**Cawston Parish Council, Norfolk Boreas Offshore Wind Farm Inquiry, Deadline 13 submission.**

Cawston Parish Council wishes to make the following submission at Deadline 13. This includes points made in oral contributions at the Open Floor Hearings on 2<sup>nd</sup> (OFH 2) and 16<sup>th</sup> July (OFH 3c) and a report on our meeting with Vattenfall on 21<sup>st</sup> July.

PROJECT HORNSEA 3 OFF-SHORE WIND FARM	DATE 07.03.19	DRAWING STATUS INFORMATION	
DRAWING TITLE B1145 - CENTRE OF CAWSTON MITIGATION SCHEME HGV - HGV PASSING POINTS	SCALE(S) AS	DESIGNED AF	
CLIENT ORSTED	SHOWN AS	CHECKED PZ	
	JOB No 1554	APPROVED PZ	
	DRAWING No 03/332	REVISION B

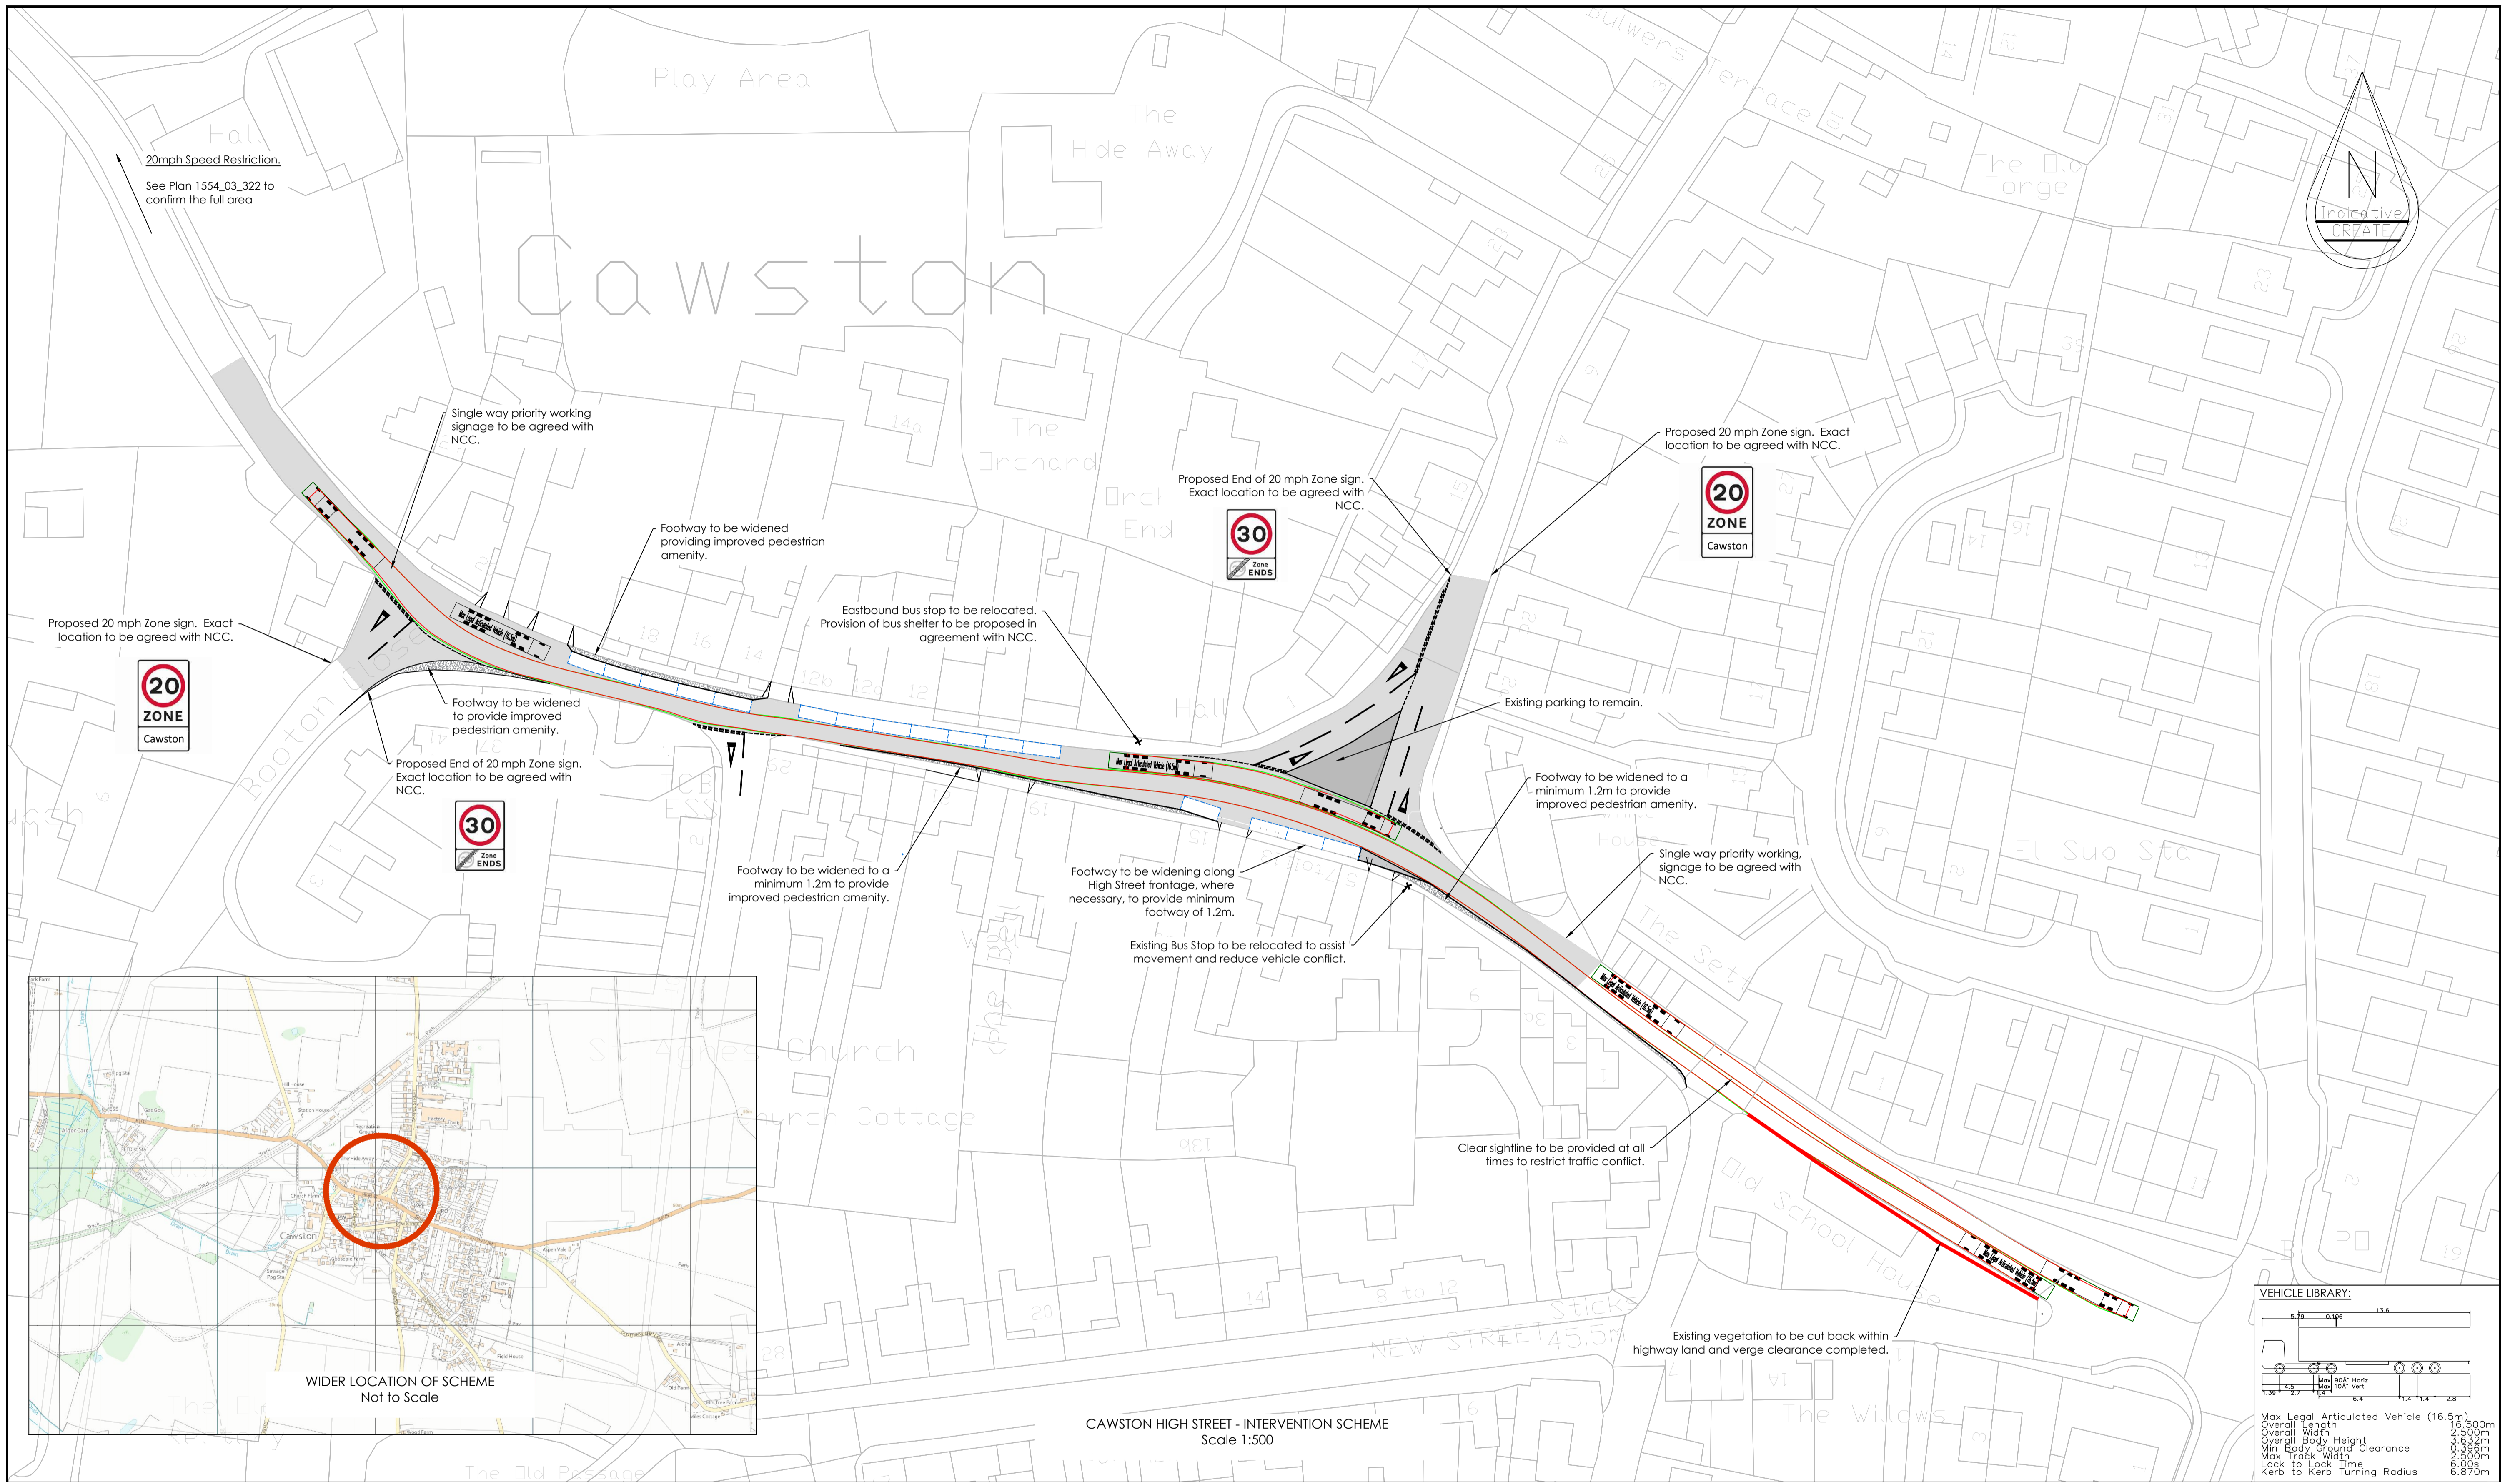
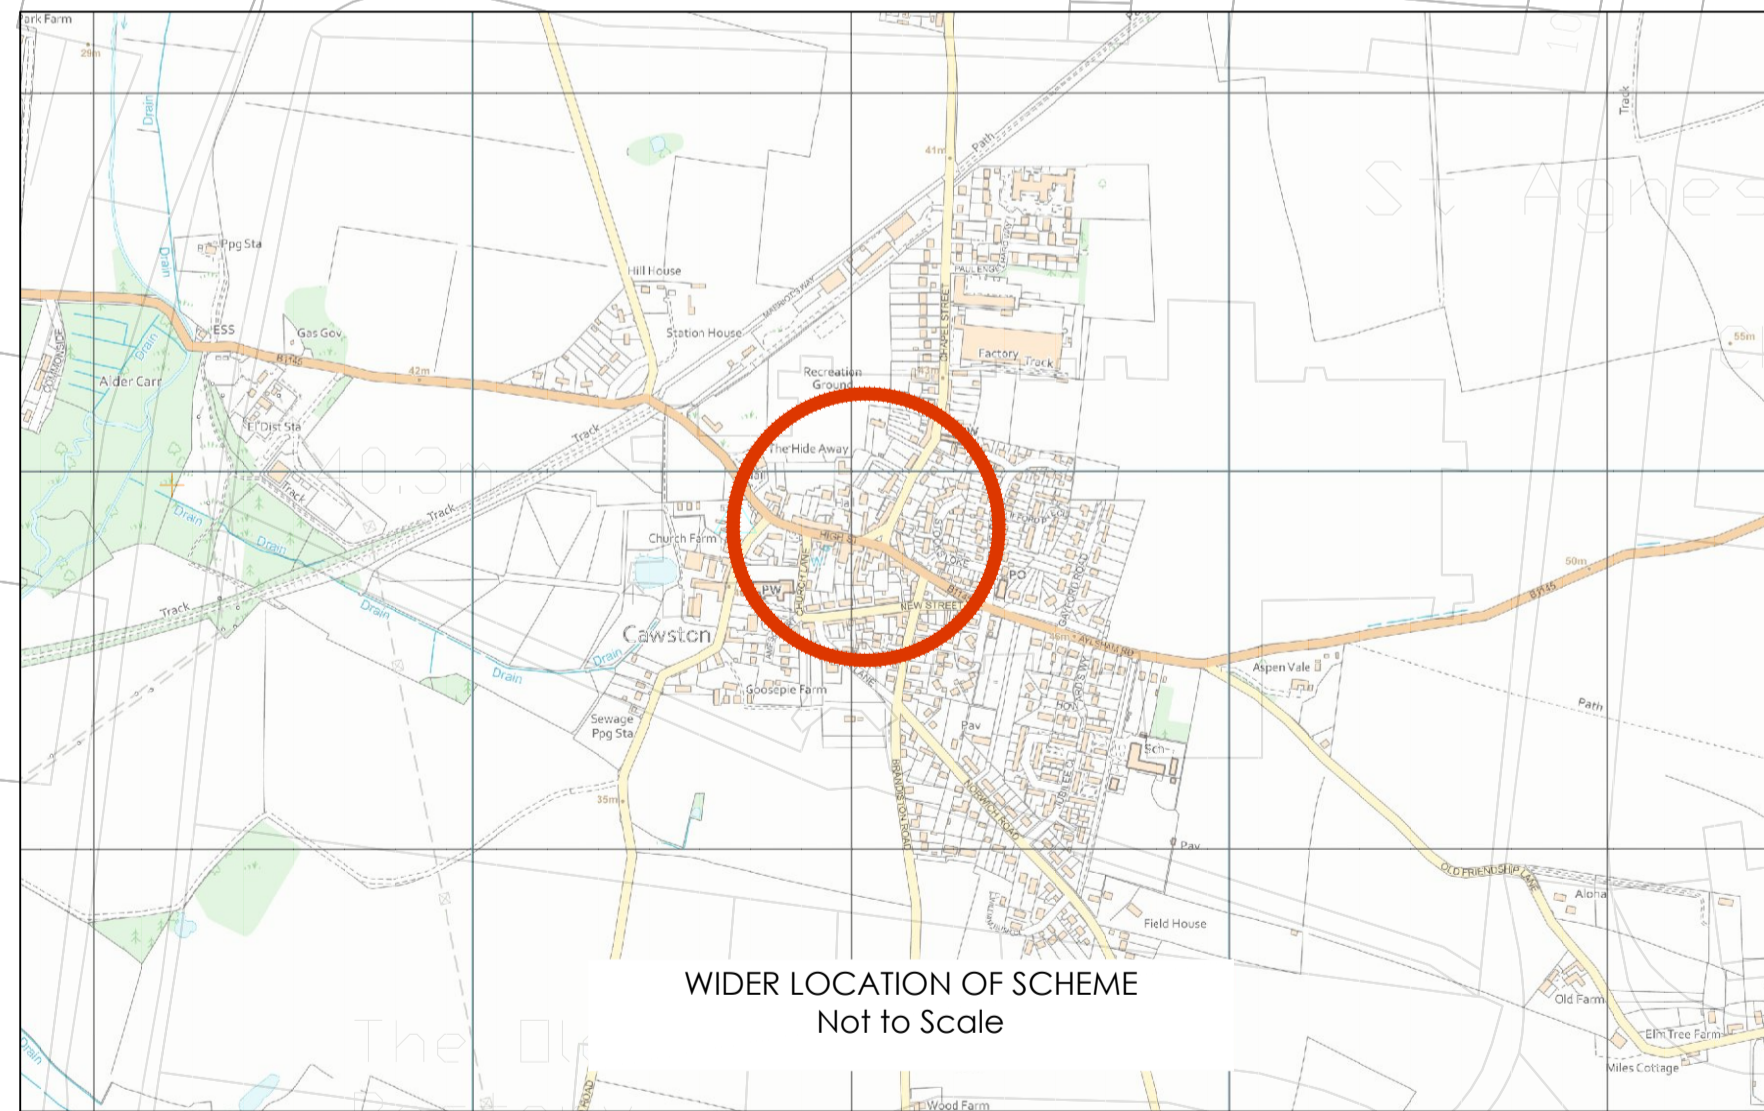
The applicant's forward visibility plan has green lines marked from the junction with Booton Lane which show a line of 50 metres which is to be kept clear at all times to restrict HGV conflicts. These lines can only provide visibility when there is no traffic ahead of the HGV obscuring the view. The Applicant claims that an HGV stopping distance at 20mph is 26.7 metres

The Highway Code states "In wet weather, stopping distances will be at least double those required for stopping on dry roads". Double 26.7 is 53.4m. Clearly the distances would increase exponentially at the higher speeds which can be expected on the actual road, outside the computer model.
